320180594

Application for a non-material amendment following a grant of planning permission.

THE DEVELOPMENT PROPOSAL IS THE CREATION OF A BALCONY OVER EXISTING EXTENSION.
THE APPLICATION REF 3/2016/0459 11th MAY 2016
REFUSED 27th JUNE 2016; APPEAL DECISION
ALLOWED + GRANTED REF APP/T2350/D/16/3158592
19th DECEMBER 2016.
APPROVED PLAN 65/16 REVISION A DATED MAY 2016

65/16 REVISION B - ACCESS FROM BEDROOM,
GLAZED SCREEN 1.1mtr HIGH

existing and proposed elevation from rear garden

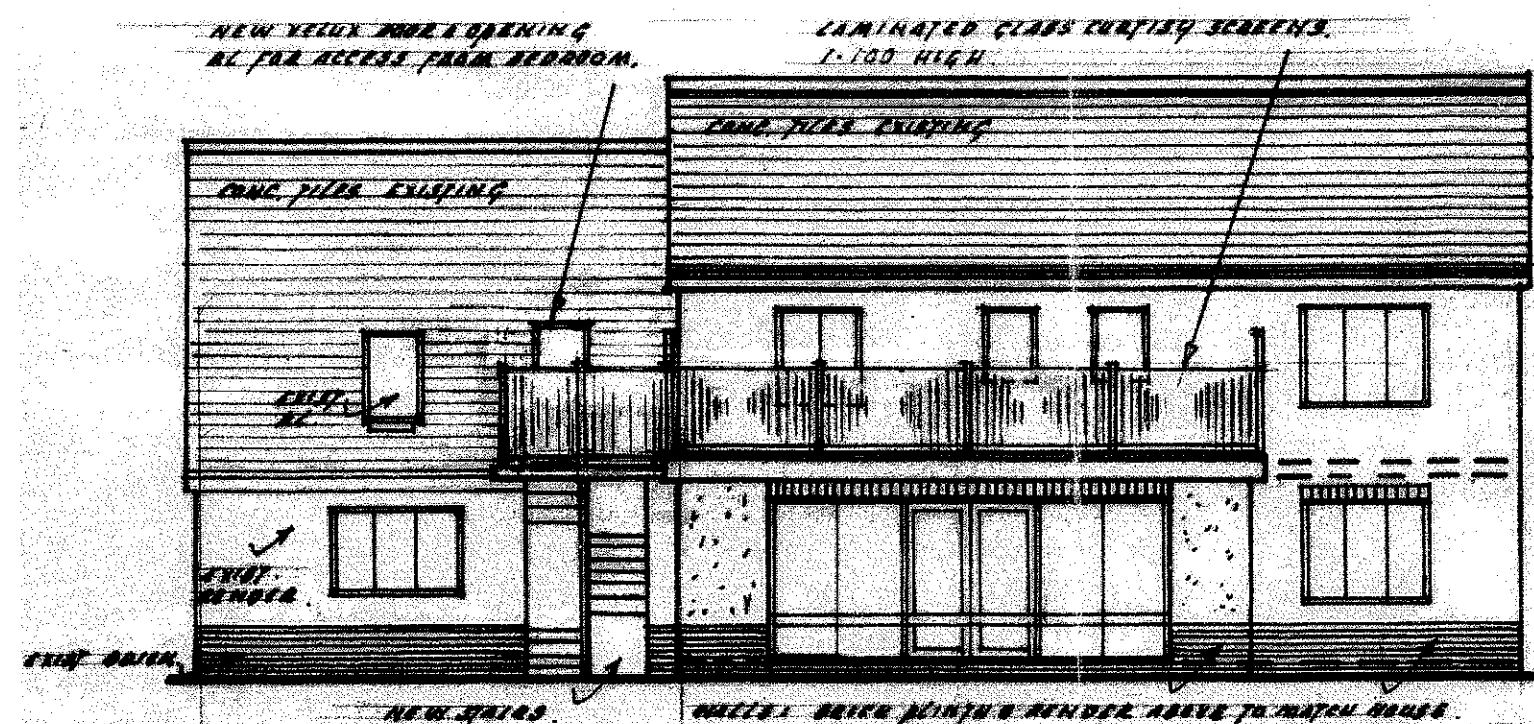
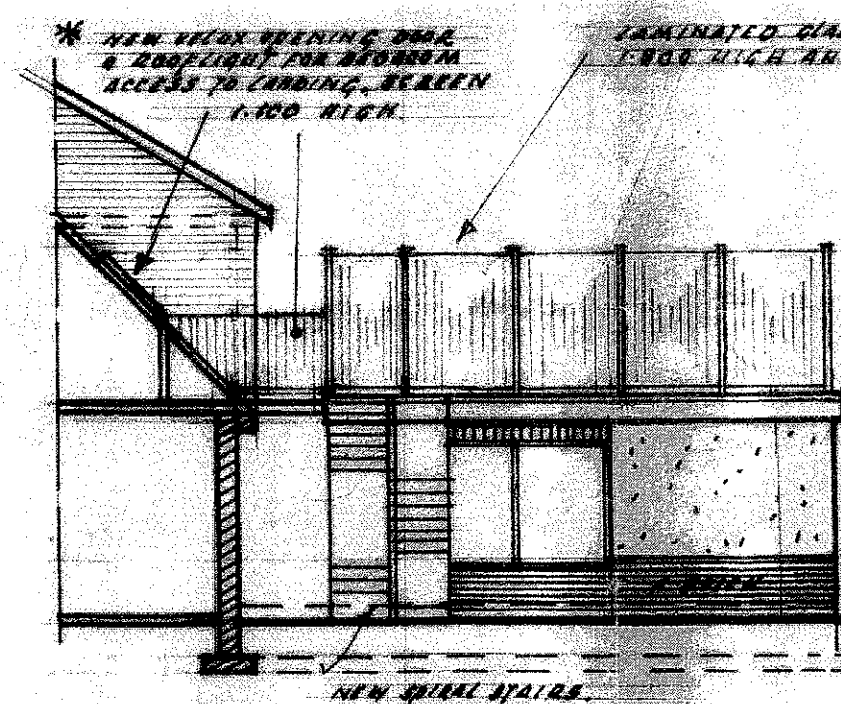
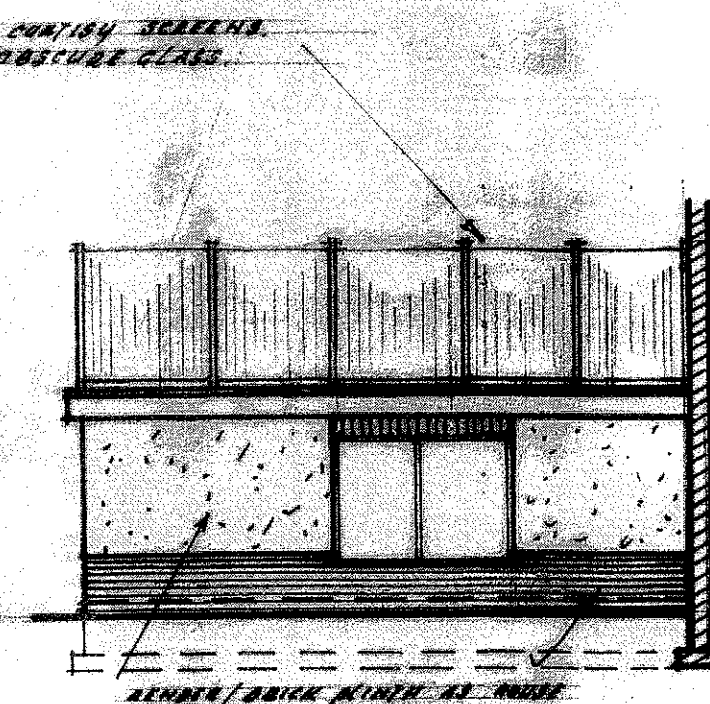
REDUCTION OF GLASS HEIGHT ON WALKWAY
EXITING BEDROOM (VIA VELUX ROOF SYSTEM)
TO RIGHT HAND SIDE (FACING SIDE OF 8
PENDLE DRIVE) FROM 1.8mtr OBSCURE GLASS
TO 1.1mtr CLEAR GLASS.

AFTER DISCUSSION WITH GREG LAWSON, PROPOSED
BUILDER AND HOUSEHOLDER, THE 1.8mtr HIGH
GLASS CAUSED CONCERN WITH HEIGHT AND
CONCERNS OVER STABILITY AND CONNECTION TO
THE ROOF. THEREFORE NOT DEEMED FEASIBLE
AND REQUIRED LOWER 1.1mtr GLASS FOR IT TO WORK.
